# Namoi Water

**Submission to the Review of Environmental Impact Statement –**

**Santos Narrabri Gas Project**

**2017**

Figure 2-2 Schematic of geology of the project area showing target coal seams

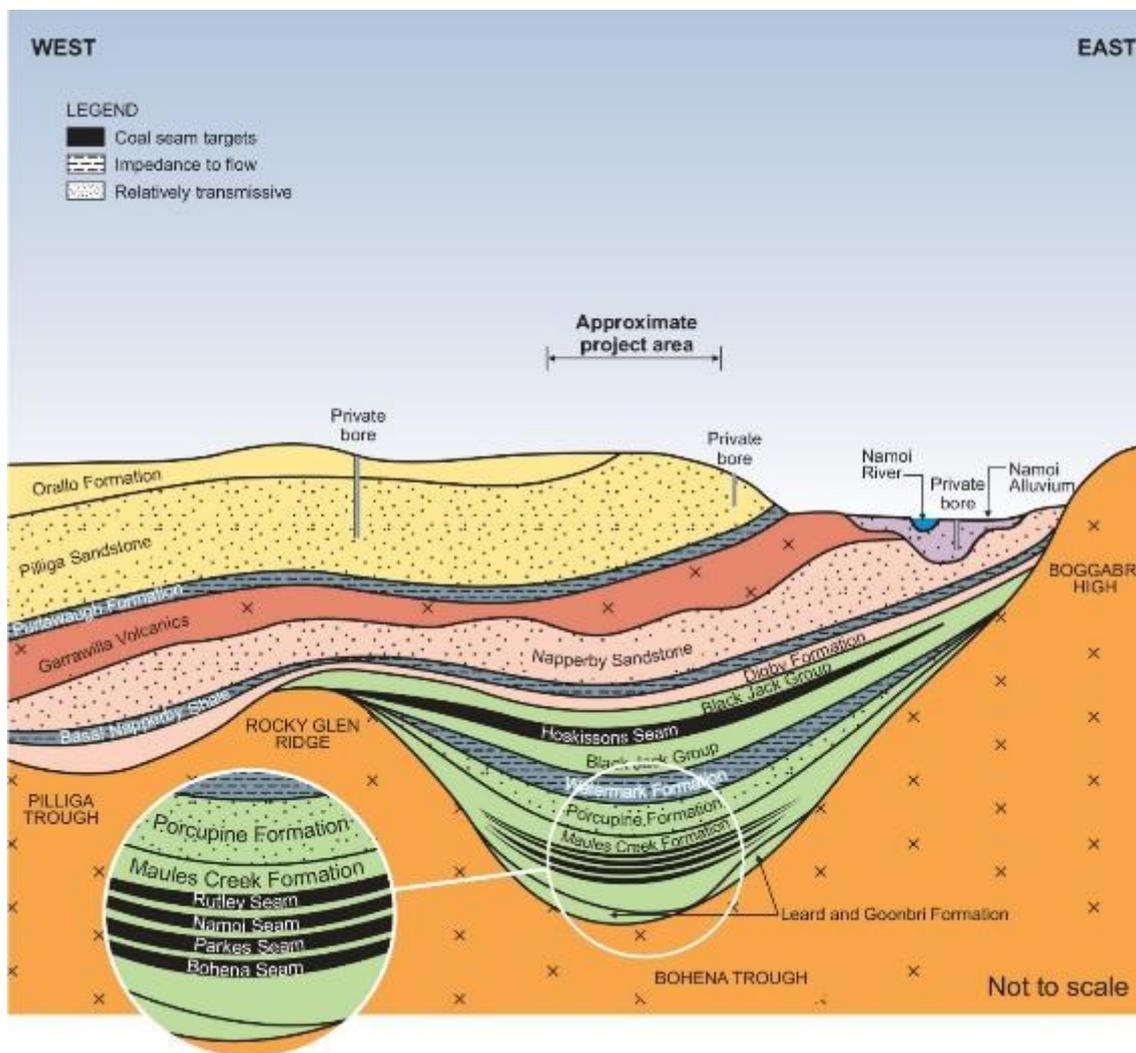
The Santos Groundwater Report states ;

The map below clearly shows this statement to be incorrect.

The 1:250,000 geological map the Namoi Rv flows over the Purlawaugh Formation.

Namoi Rv  
Flows over the  
Jurassic Formations  
R-Jb
